DAVID PACHECO, agent(s) for VERNON DORRIS, request(s) the above action(s) for all or a portion of Tract(s) 11, **ALAMEDA BUSINESS PARK**, zoned SU-2, IP-EP, located on ALAMEDA BLVD NE between EDITH NE and JEFFERSON NE containing approximately 1 acre(s). [REF: DRB-98-223, V-99-9, 10001321, 1003114] *[Deferred from 3/24/04]* (C-16) **SITE PLAN FOR BUILDING PERMIT WAS APPROVED AND SIGNED OFF BY THE BOARD.**

**CITY OF ALBUQUERQUE
PLANNING DEPARTMENT
Development Review Board
April 7, 2004
Comments**

RE: Alameda Business Park, Tract 11/SPBP

**SITE DEVELOPMENT PLAN for BUILDING PERMIT**

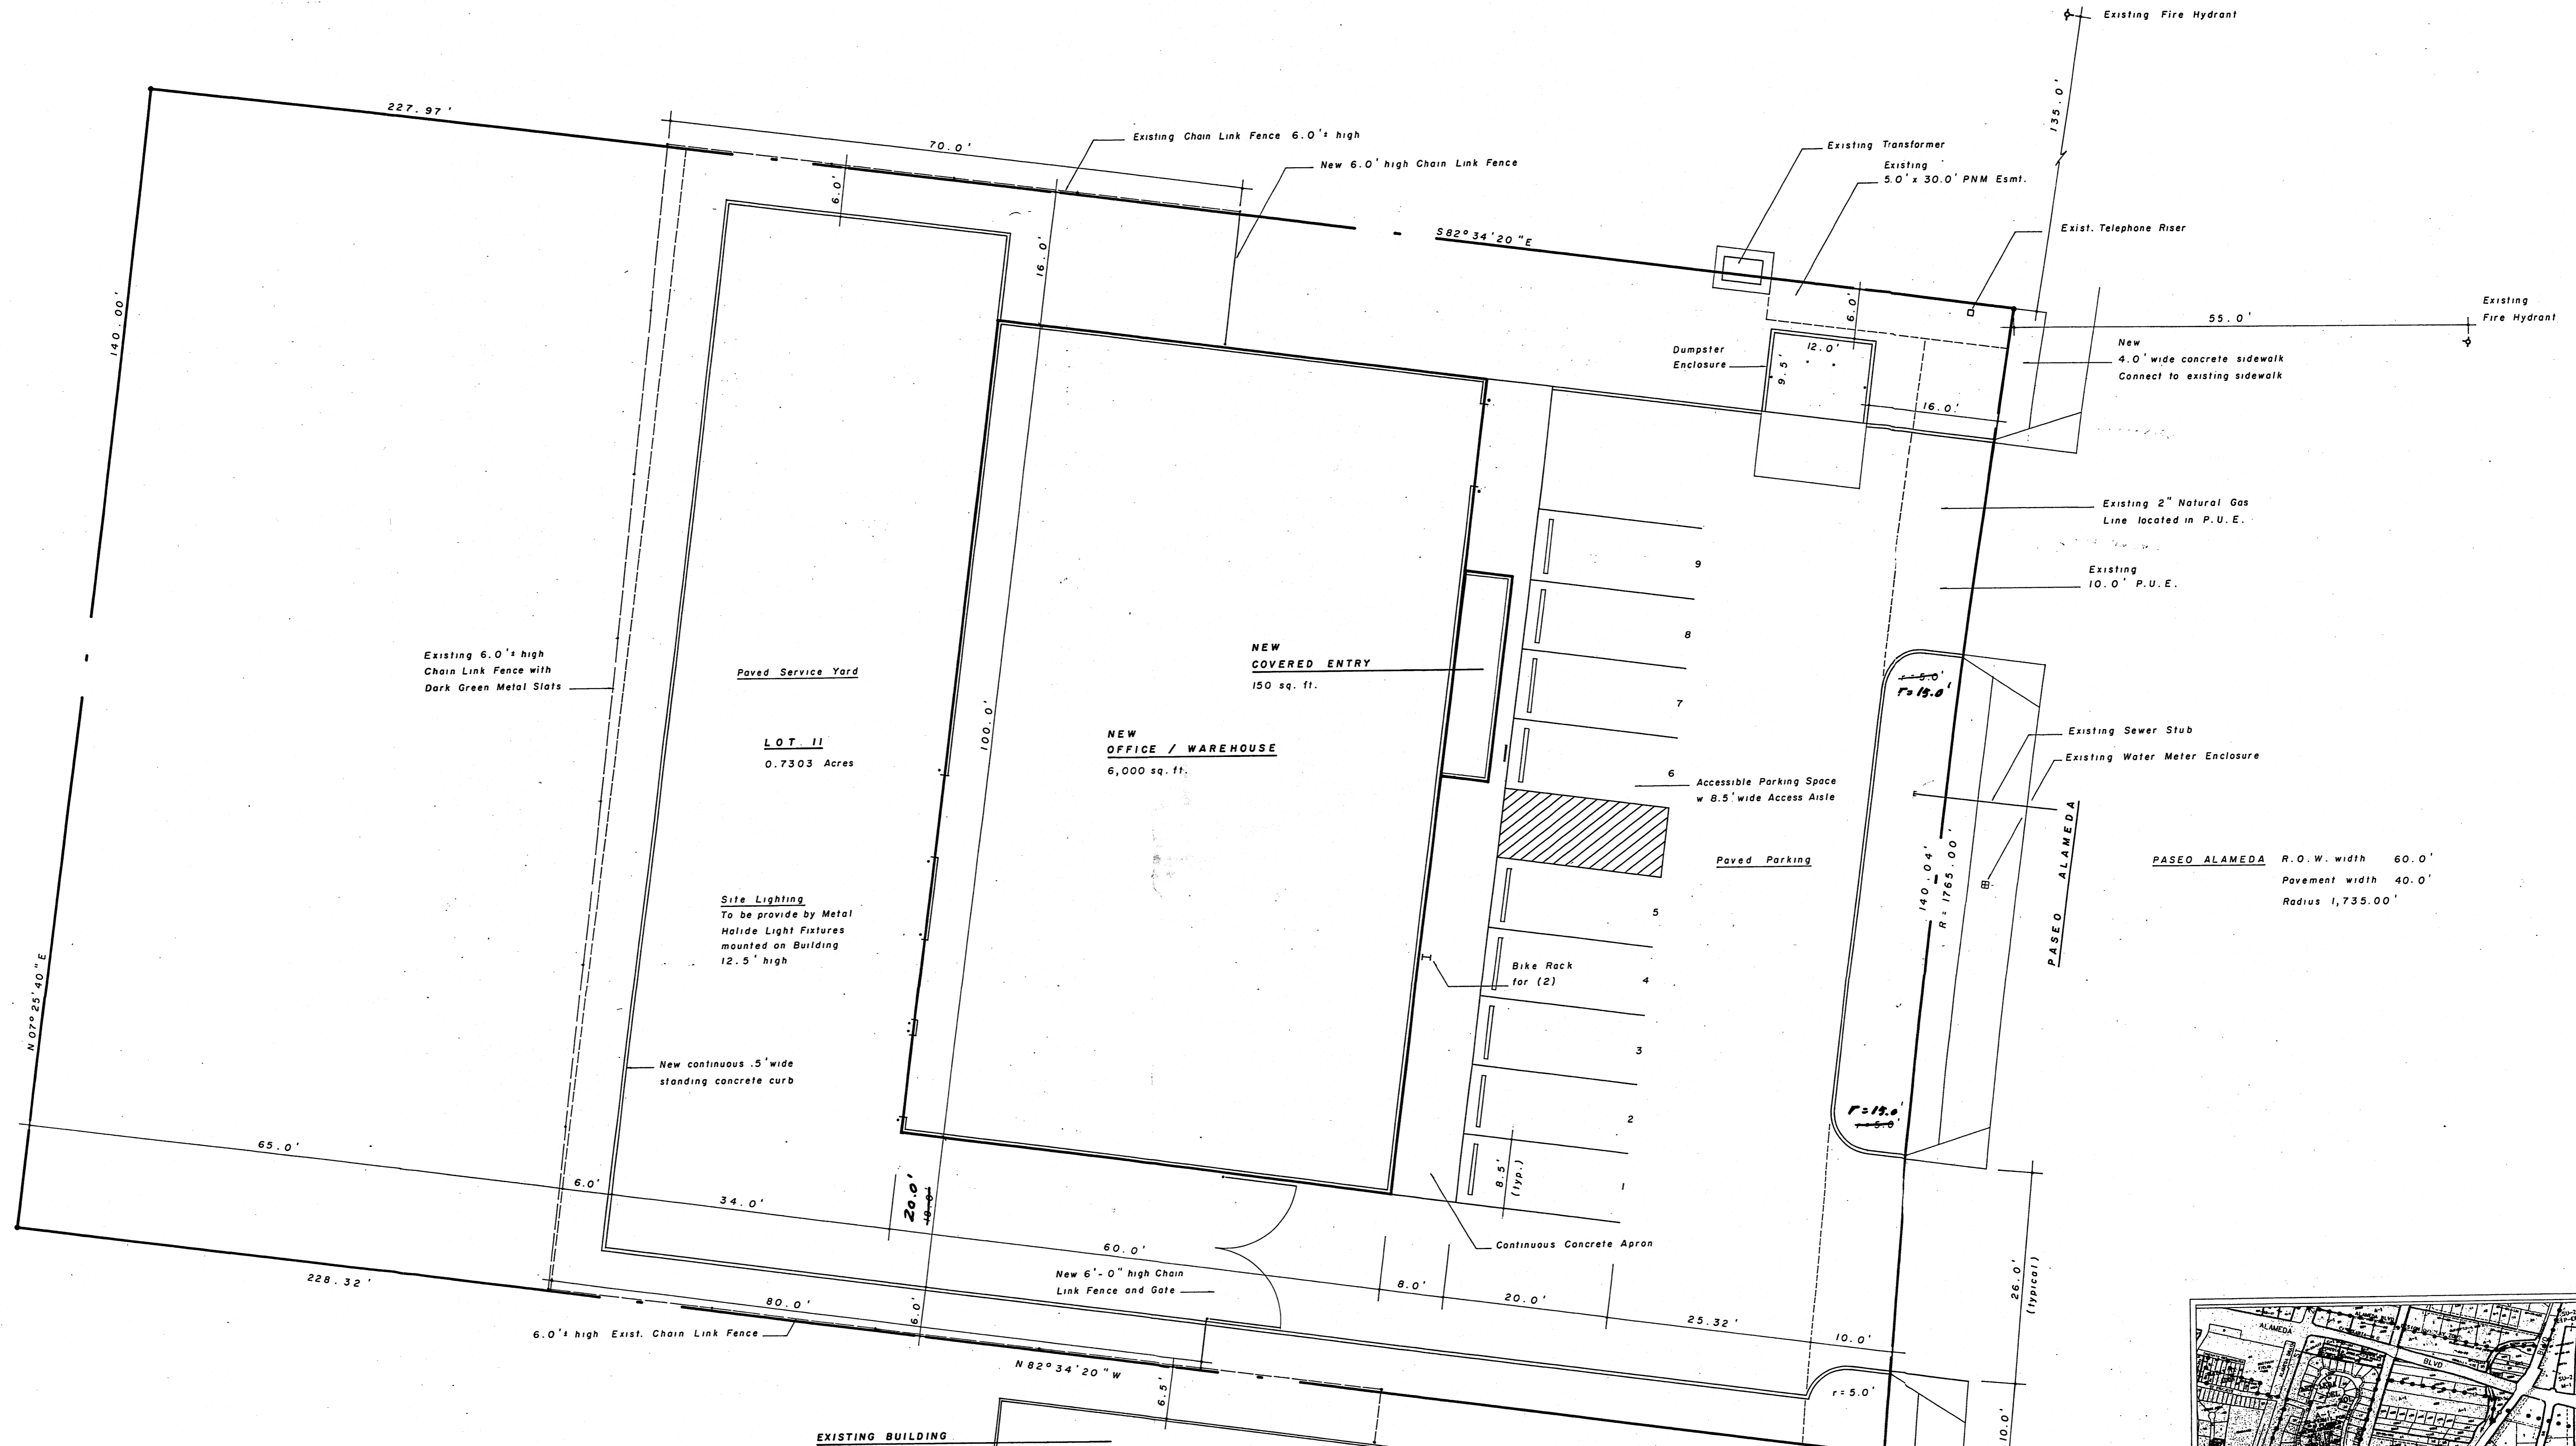
- Be sure the property lines are clearly identified on the SPBP sheet as well as the Landscape Plan.
- Landscape Plan: The water usage of each plant should be indicated by "H,M,L".
- The length & width of each planting area should be indicated as well as the square footage.
- Only one sign is indicated. It's on the building. Is this the only sign planned? *Yes*
- The site plan sheet should be labeled "Site Development Plan for Building Permit".
- Be sure to use the correct signature block. A copy is available at the Front Counter.
